PLANNING CONSULTATION RESPONSE

Application No	2025/0945
Proposal	Change of use from Class B8 (Storage and Distribution) to Class E(d) (Indoor Sport and Recreation) to provide 5no. Padel Courts and enclosures with ancillary café/ bar services and upgrades to internal lighting.
Address	Unit 11 and Unit 12, Darton Business Park Barnsley Road, Darton, Barnsley, S75 5QX
Date of Consultation Reply	19/11/25
Consultee	Highways DC

CLIENT	TOPPLAY LIMITED		
JOB	DARTON BUSINESS PARK		
TITLE	PROPOSED PADEL PROPOSAL PROPOSED SITE PLAN		
DRAWN	CHECKED	DATE	SCALE
PWH	PTE	OCT 2023	A3 ISSUE: 1:1000 A1 ISSUE: 1:500
REVISION	DRAWING STATUS	DRAWING NUMBER	
		<b>1000-04</b>

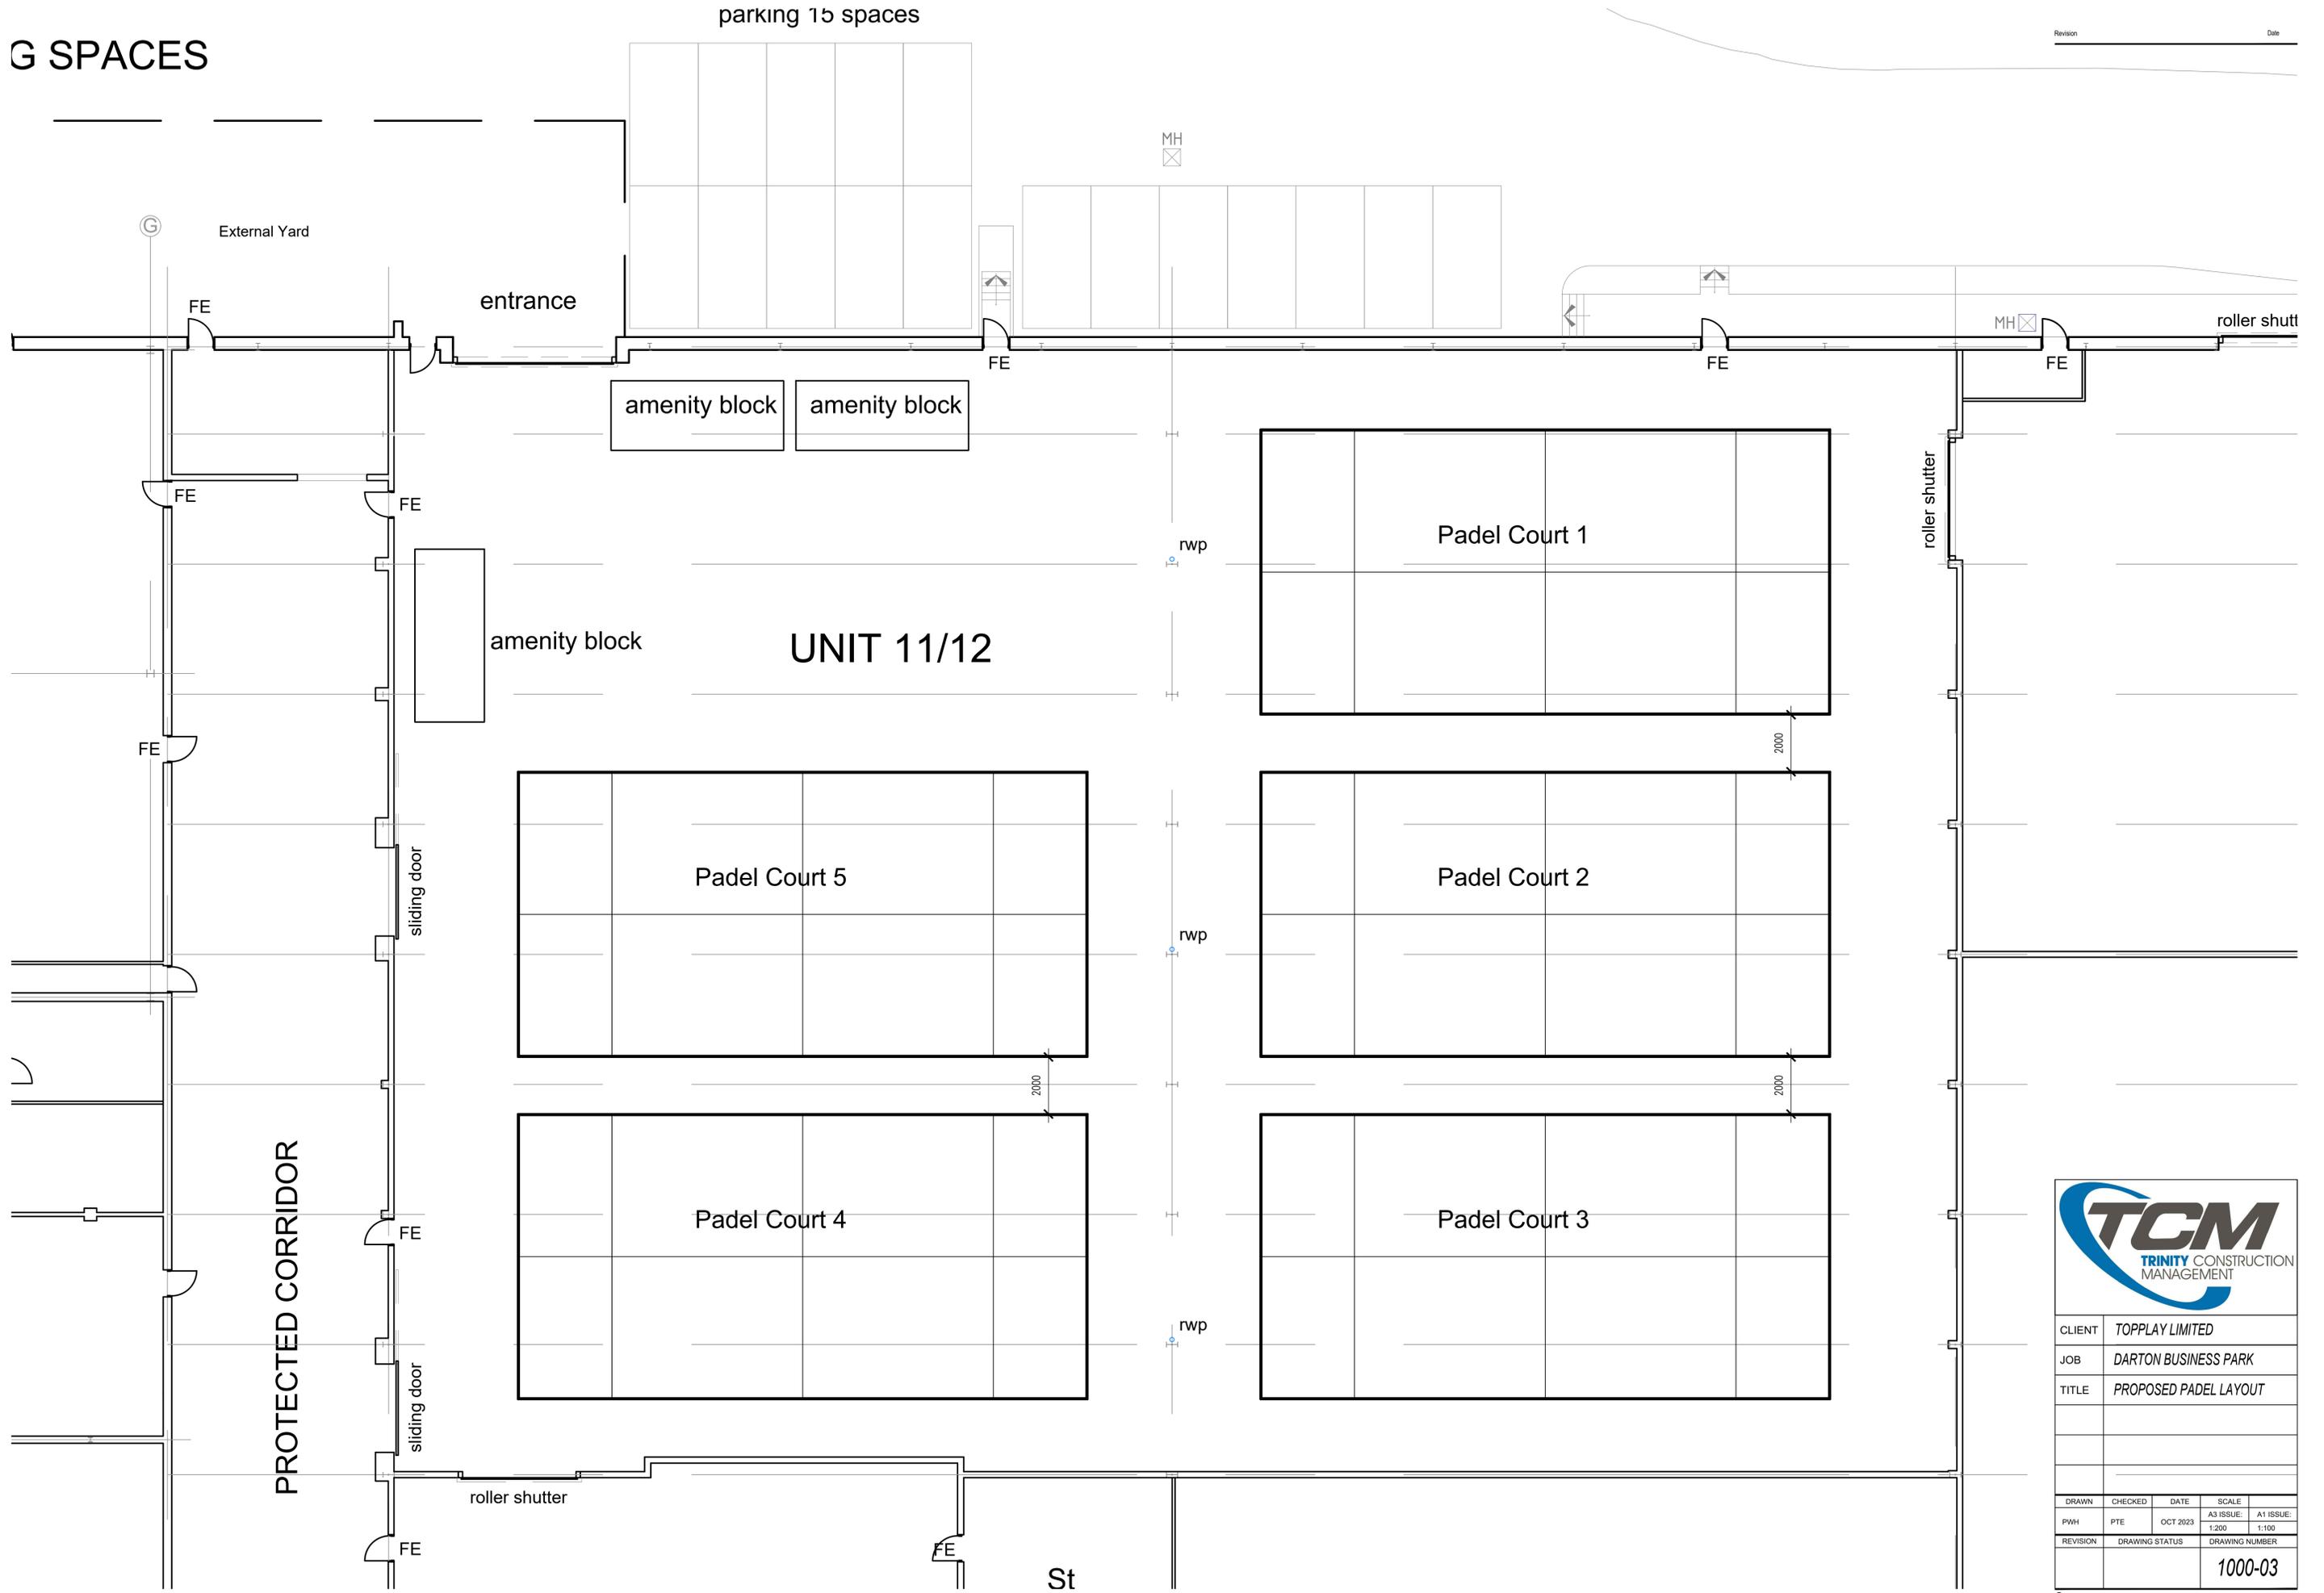
The application form and layout plan suggest that there will be an additional 27 spaces created to serve the facility, but some of these are in tandem where customers or staff could be boxed in, some of the spaces are to the front of unit 10, and others encroach into the access route for the industrial units; none of the spaces are likely to be able to be reserved solely for the use of the padel court customers. The spaces are also outside of the red line boundary shown on the site plan, so the land may not be under the applicant's control. Similarly, the red line boundary shown on the location plan does not meet the public highway, so access is not demonstrated to be retained in perpetuity.

- Although the demonstration of customer and staff parking is welcomed, there doesn't appear to be a way to retain this for the development and the land being used may not even be under the ownership of the applicant.

- The proposed parking bays appear to encroach on the access route around the business park building and reasonable clearance should be maintained.
- Some of the parking bays proposed may make the external yard inaccessible to other units especially with the difference in levels between the access route and the yard.

- Concern is raised regarding the conflict between those wishing to partake in sport and recreation both in private cars and on foot and the existing heavy commercial vehicles used by the rest of the business park; this is a particular issue where the proposed parking spaces are to be outside another unit and only accessible by walking around the external yard. A painted walkway would go some way to providing at least some segregation between pedestrians and vehicles.
